Online Comment

Application H16-1131-21
Location 38 SPRING GARDENS SPALDING
Proposal Change of use of existing building from dance/fitness studio (class E) to 2 x 1-bed flats and 5 x 2-bed flats (class C3) including the formation of a pitched roof to existing single-storey projection

Name Greg Watkinson
Address Conservation Officer

Date Submitted 27-04-22
For/Against Comments

Job Title Proposed Change Of Use Spring Gardens Spalding For: Market Homes Ltd	Date May 2021	Drawn by GT Checked by G.E
Drawing Title Planning Drawing Elevations & Location Plan	Job No. SE-1515 Dwg No. PP1100	Sheet Size A1 Revision B

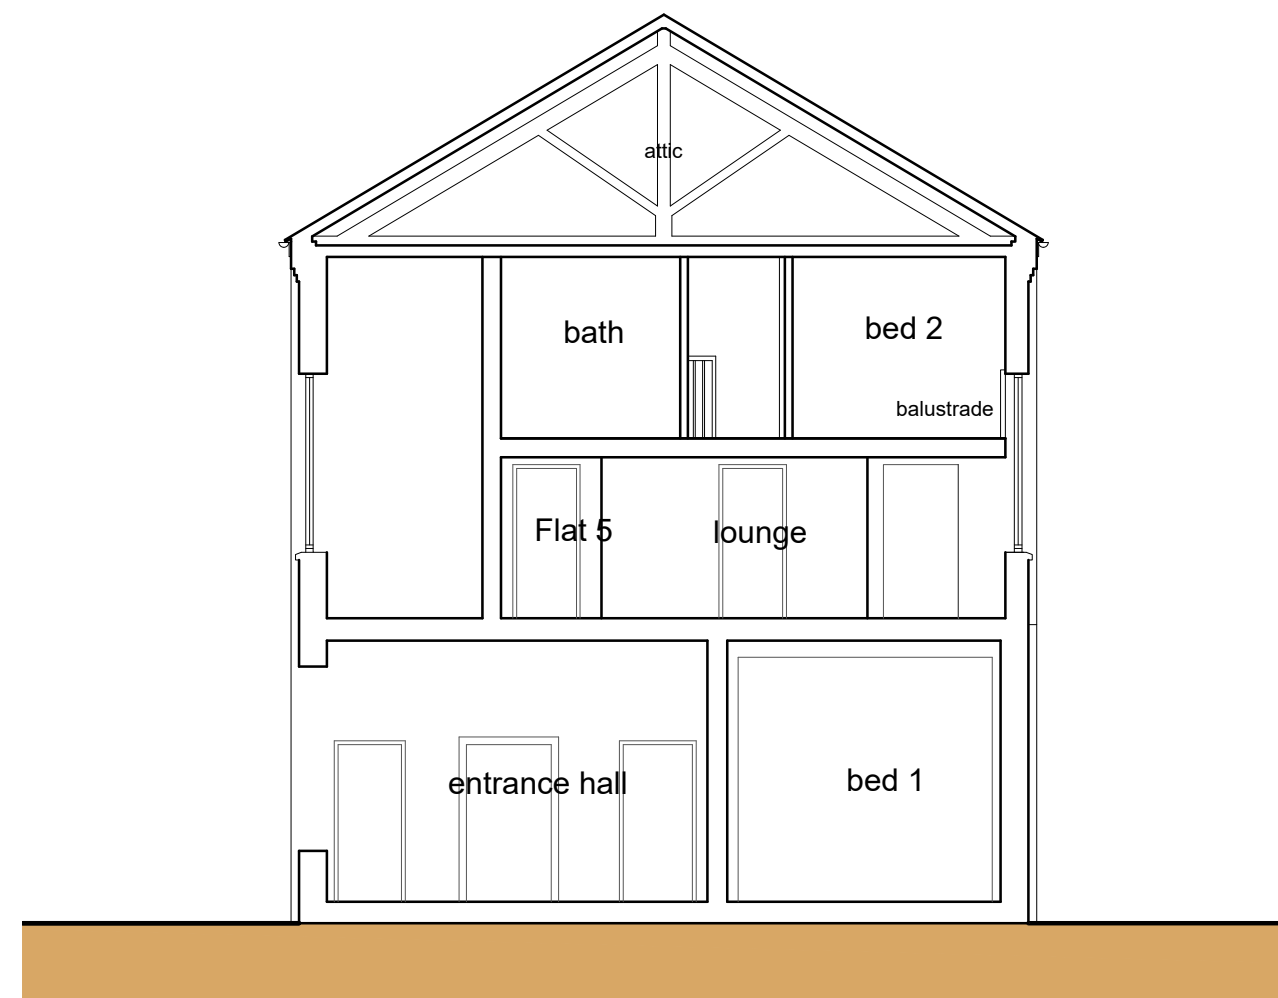
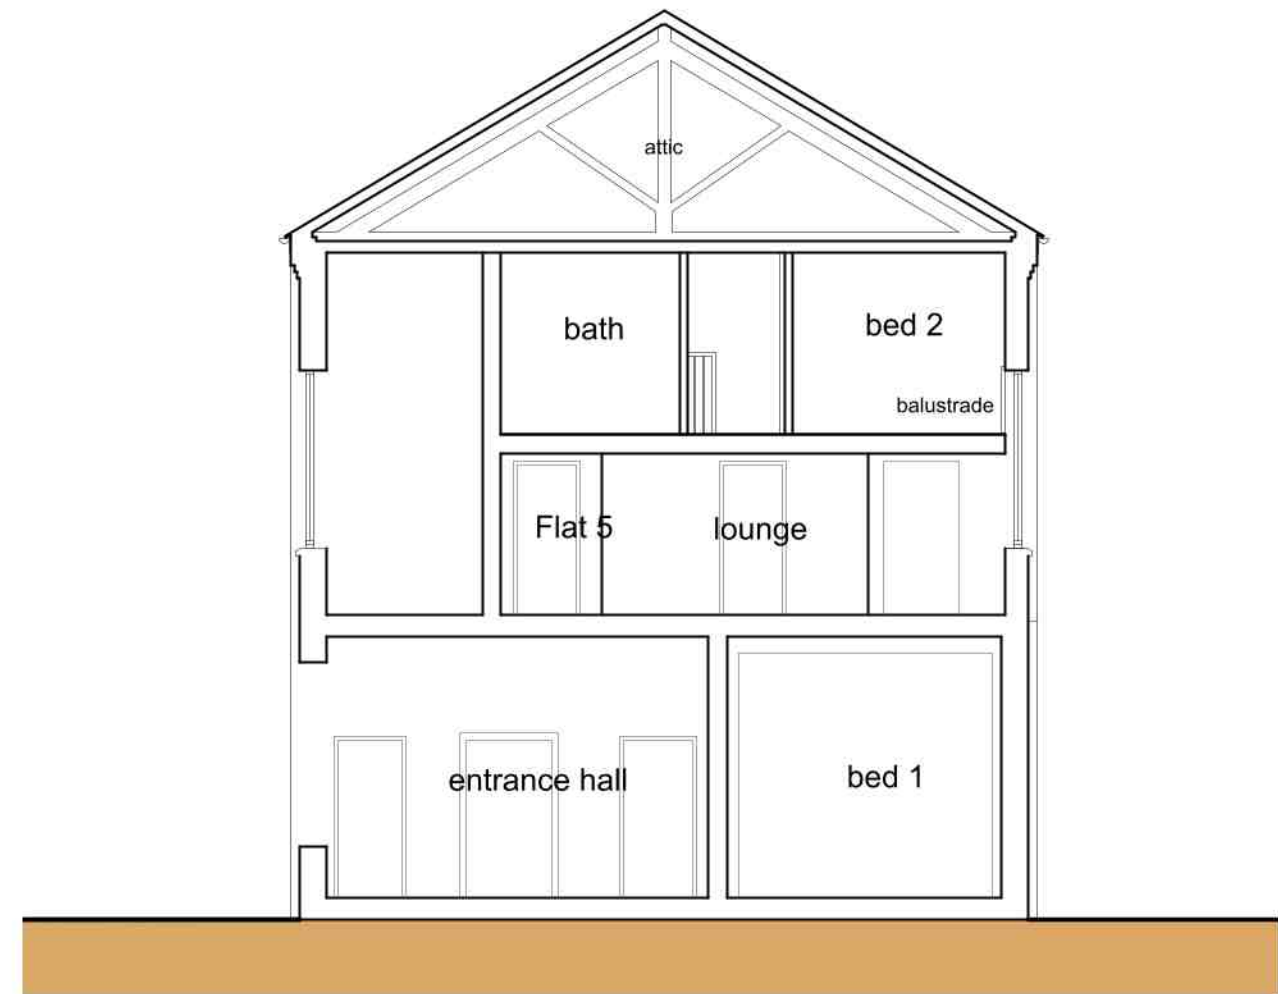
Following on from my original comments, i reiterate that, on conservation grounds, the principle behind converting this disused listed property to regular residential use is a sound one. Furthermore, I am satisfied with the proposed external alterations to the property, especially the addition of a slated pitched roof over the extant flat-roofed rear extension, which is currently a detracting factor to the aesthetic qualities of the site.

PP1000	B
--	--------	---

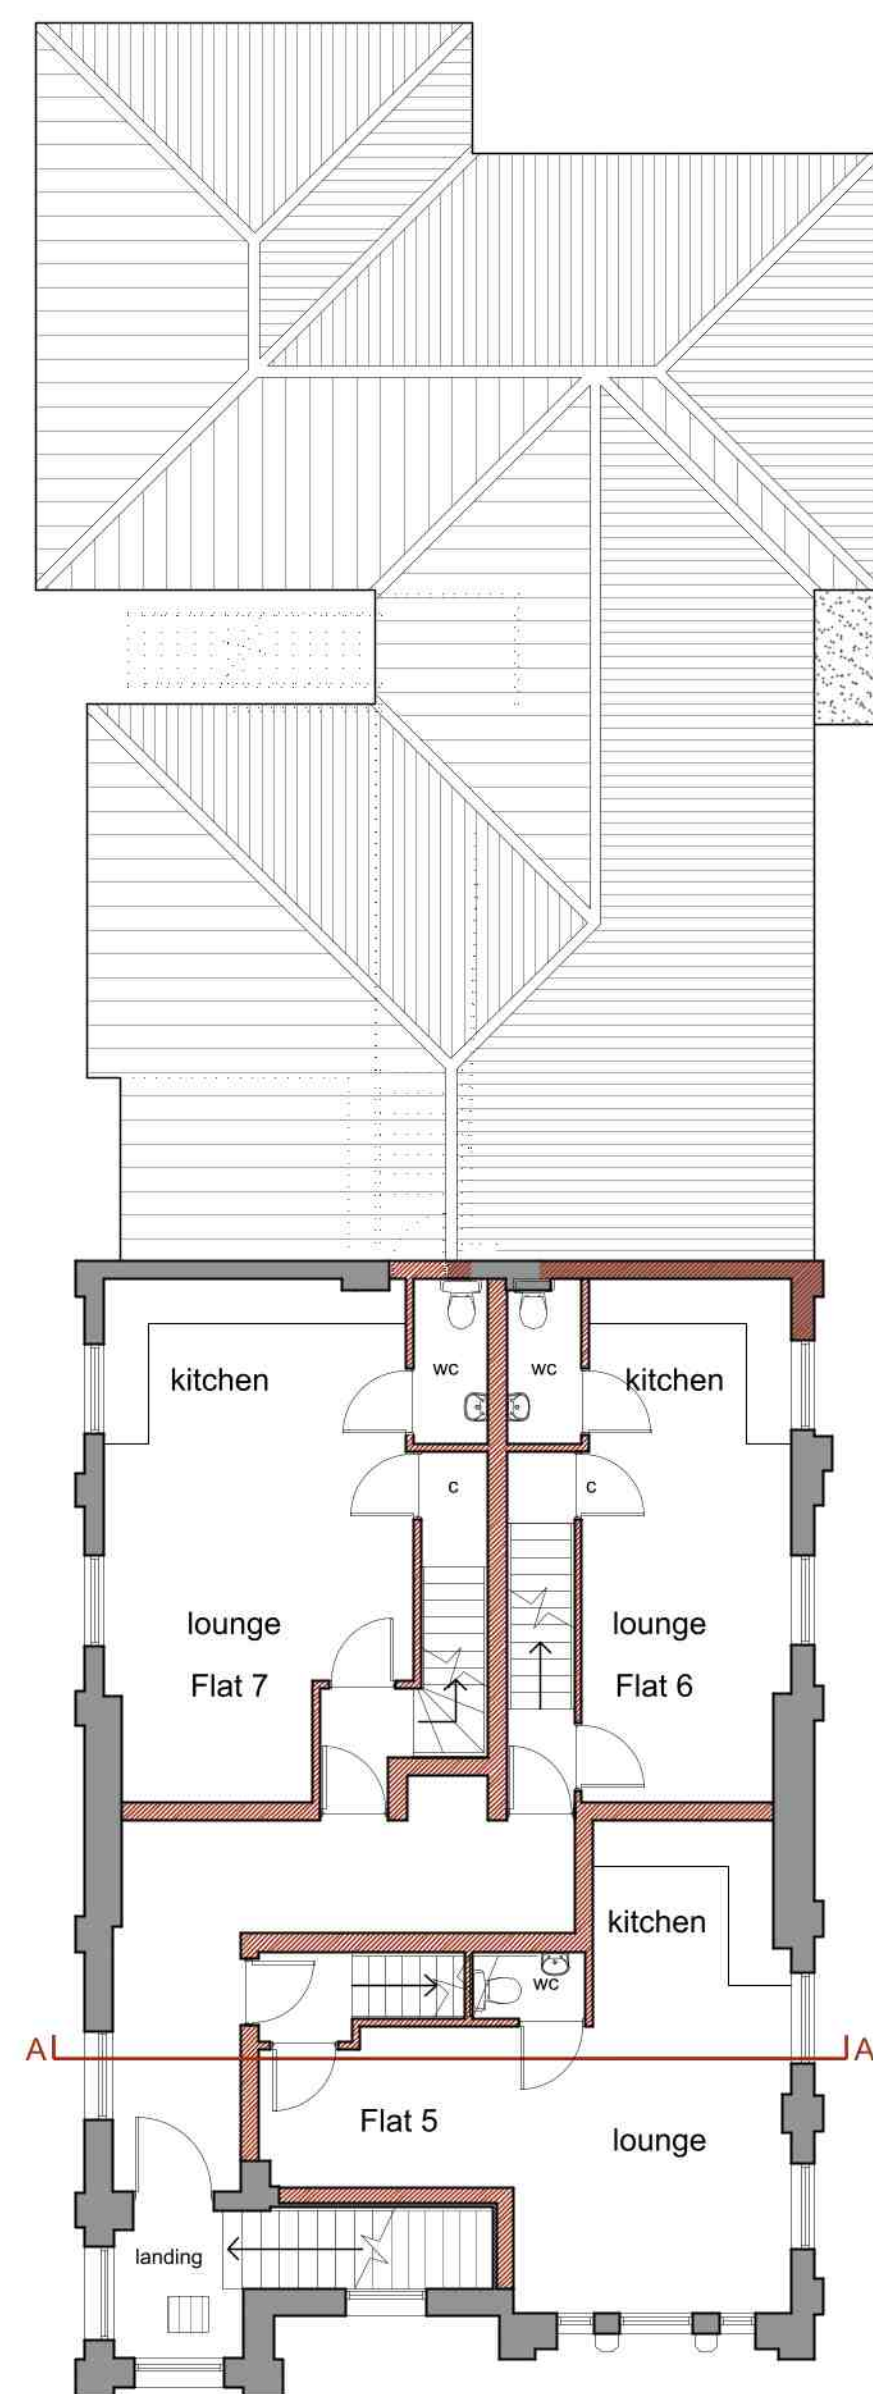
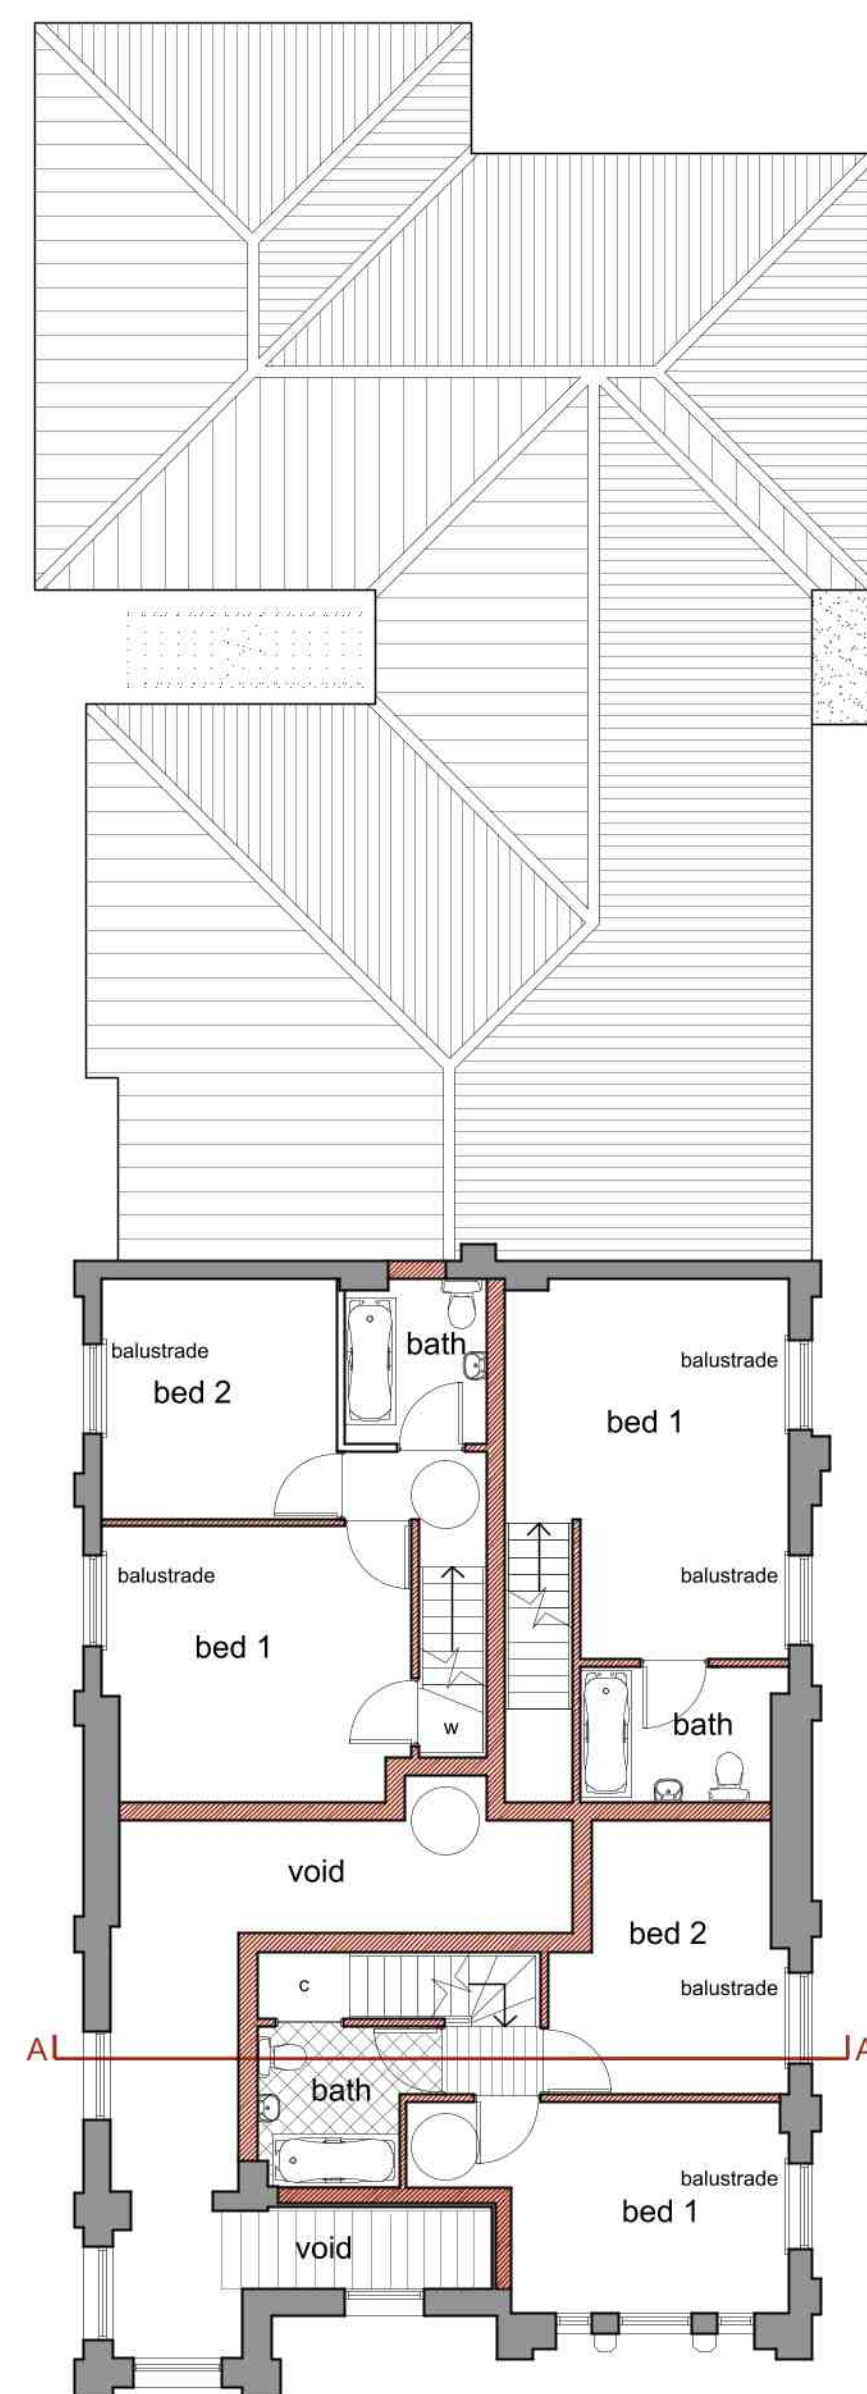
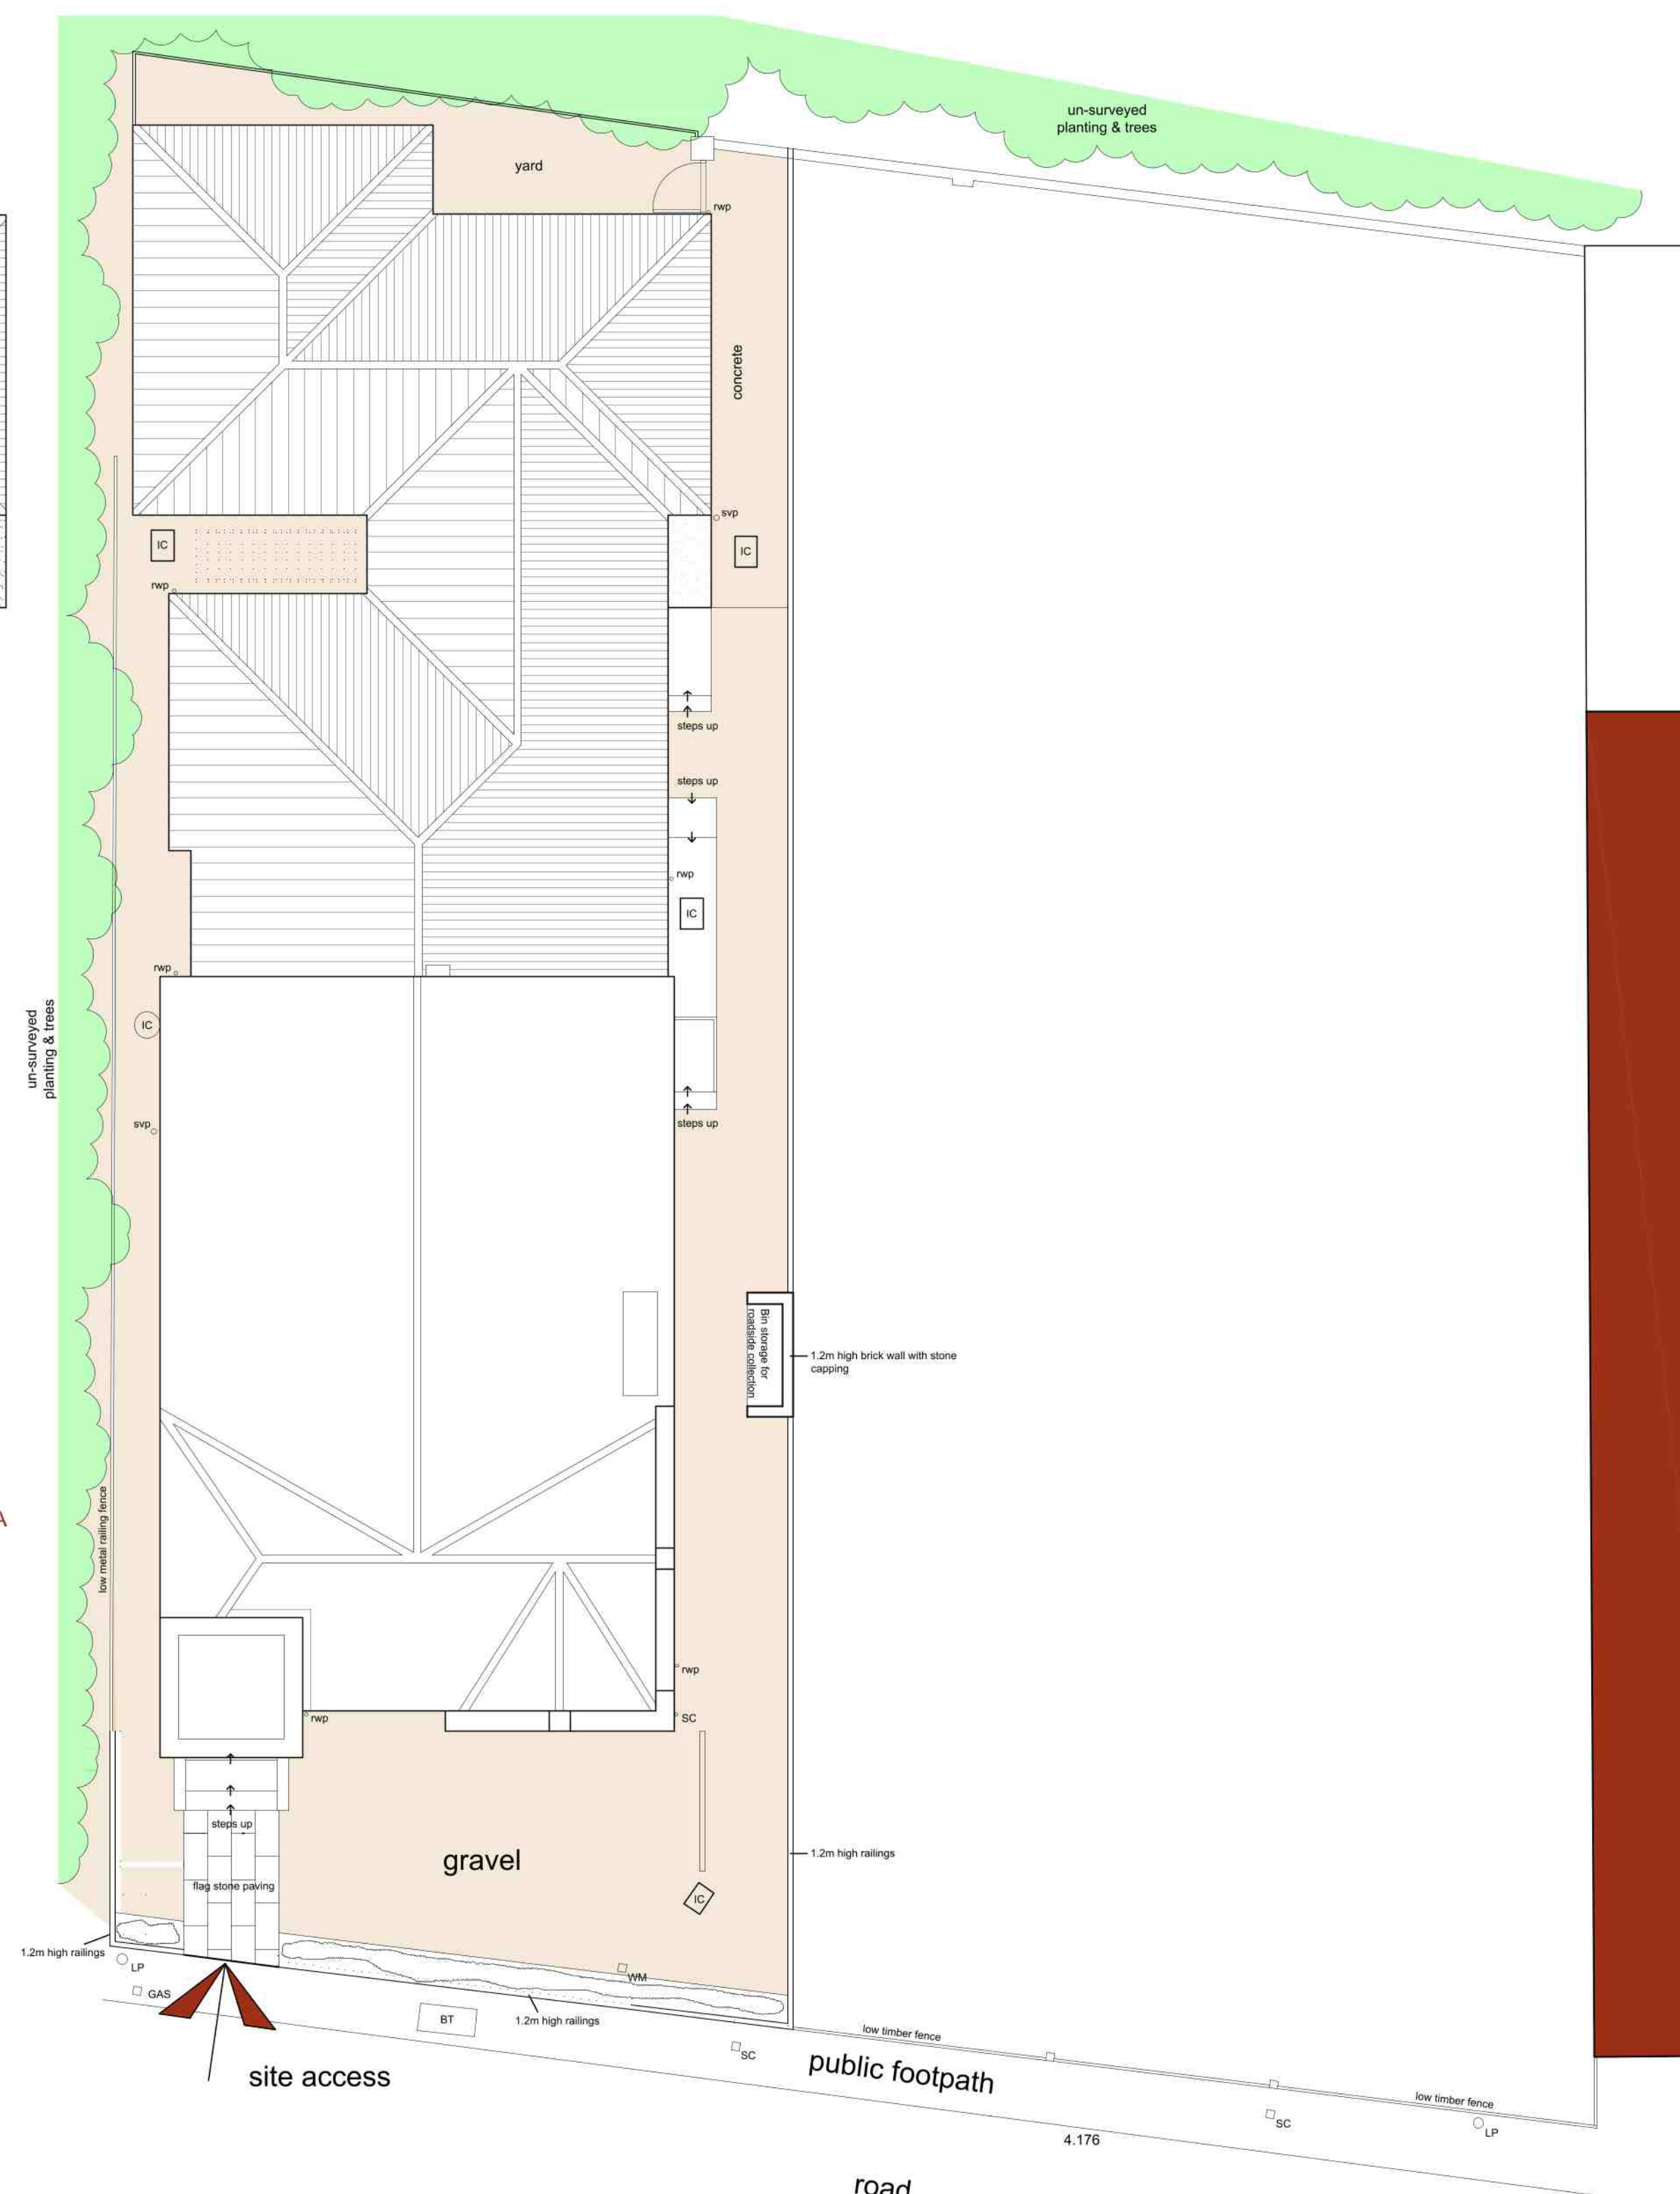
Following discussions with the applicant's representatives and subsequent revisions of the proposed floor plan, I am now satisfied that the proposed layout of the former ball room area, to be converted to apartments is satisfactory in that it preserves key architectural features and is now much more open plan, preserving the wider, open character of the space. Therefore, I have no further objections or comments, and the case officer should continue to consider the application in accordance with all relevant policies and guidance.
